Executive Summary – State Significant Development Application - Block 1 (SSD 6554)

This is the executive summary to accompany the PPR documentation prepared in response to the letters received from the Department of Planning and the Environment dated 27th November 2014 and the City of Sydney dated 31st October 2014. The letters relate to the State Significant Development Application for a Mixed-use Building , Block 1 (SSD 6554) at Central Park, Chippendale. This executive summary primarily relates to the architectural items raised within these letters. For any other non-architectural items, please refer to the wider submitted PPR documentation for the dedicated reports and studies by the wider Design Team for the project. In the first instance, please refer to the covering summary letter provided by JBA for direction.

Title
BLOCK 1+4N
BASEMENT 01

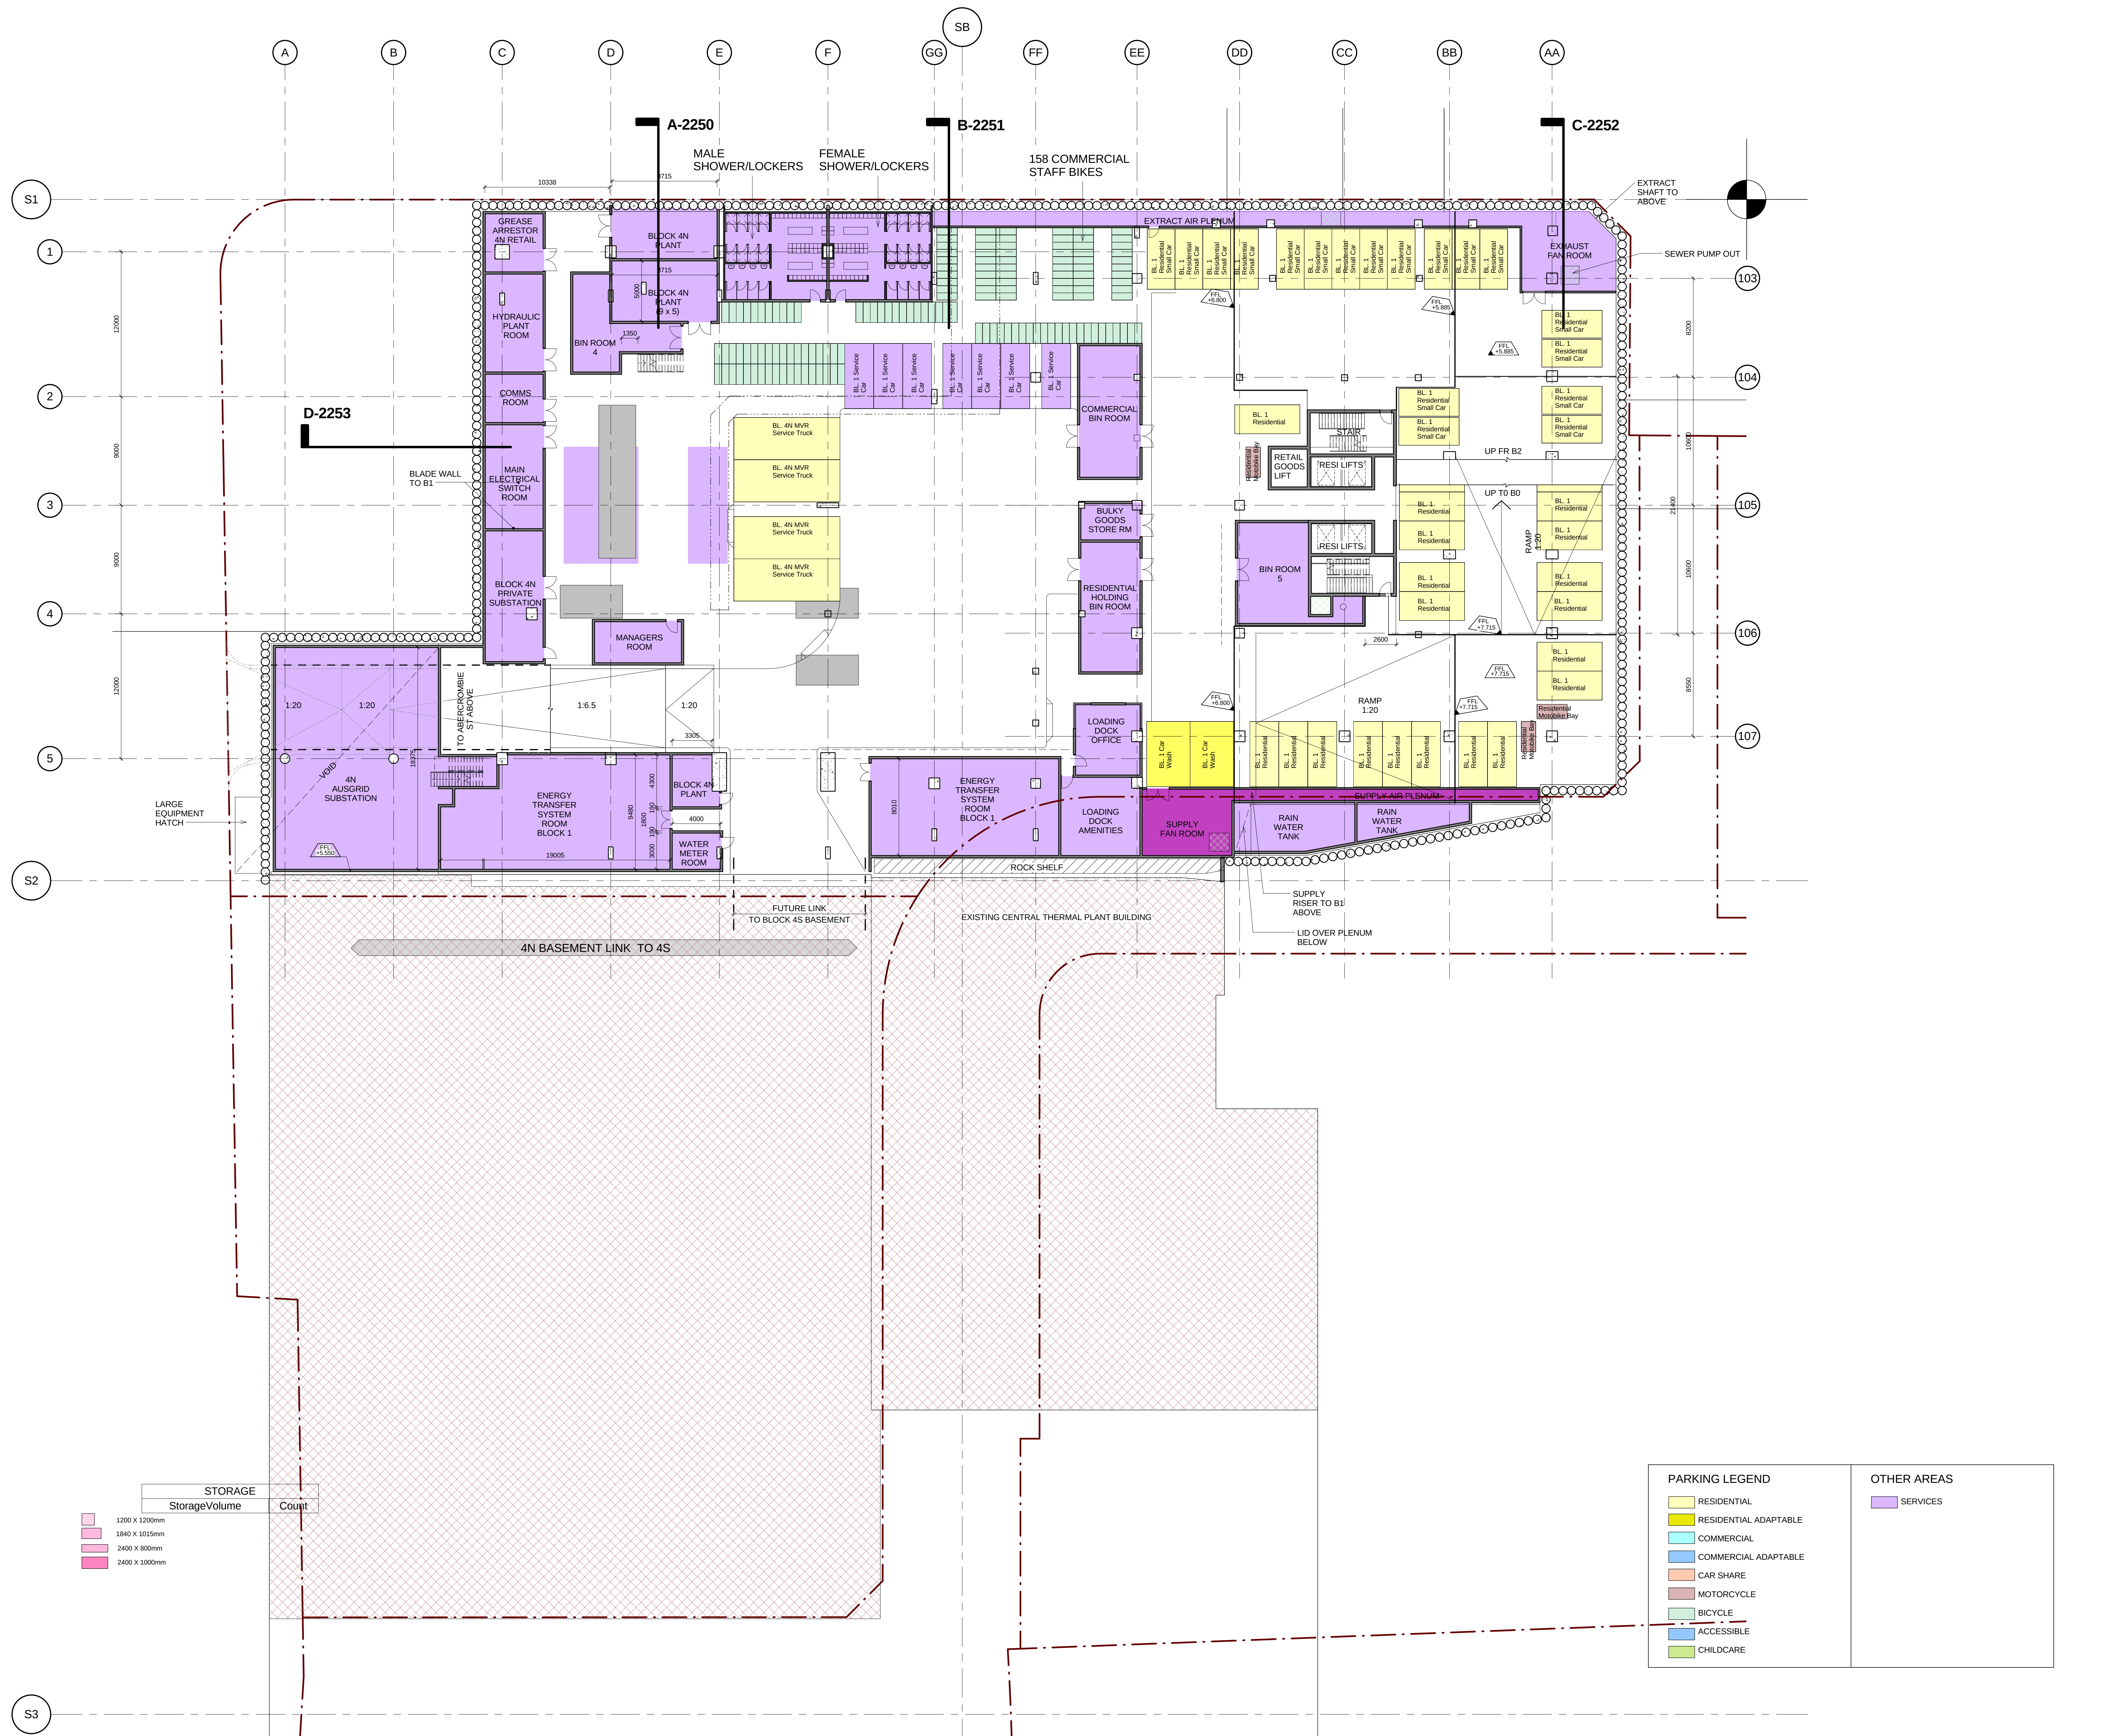
Amended basement plans that incorporate the “construction” of the basement into only one of the applications (either to be built in conjunction with Block 4N or in conjunction with Block 1) and should be deleted (or shown as indicative only) on the other application.

All bicycle parking spaces and storage areas should be shown on the relevant set of basement plans.

The PPR documentation has been revised to now illustrate each apartment typology within the building. This is reflected in the PPR drawings PA-A1-1755 to PA-A1-1759 inclusive. This is also reflected within the GA sections within the PPR documentation. The relevant information within the Block 4N PPR documentation have been revised to cross-reference with the Block 1 PPR documentation.

The PPR documentation has been revised to now indicate the bicycle parking and storage areas within the basement of the building. This is reflected in the PPR drawings PA-A1-1755 to PA-A1-1759 inclusive. The spreadsheet indicated on PA-A1-1020 should also be referred to.
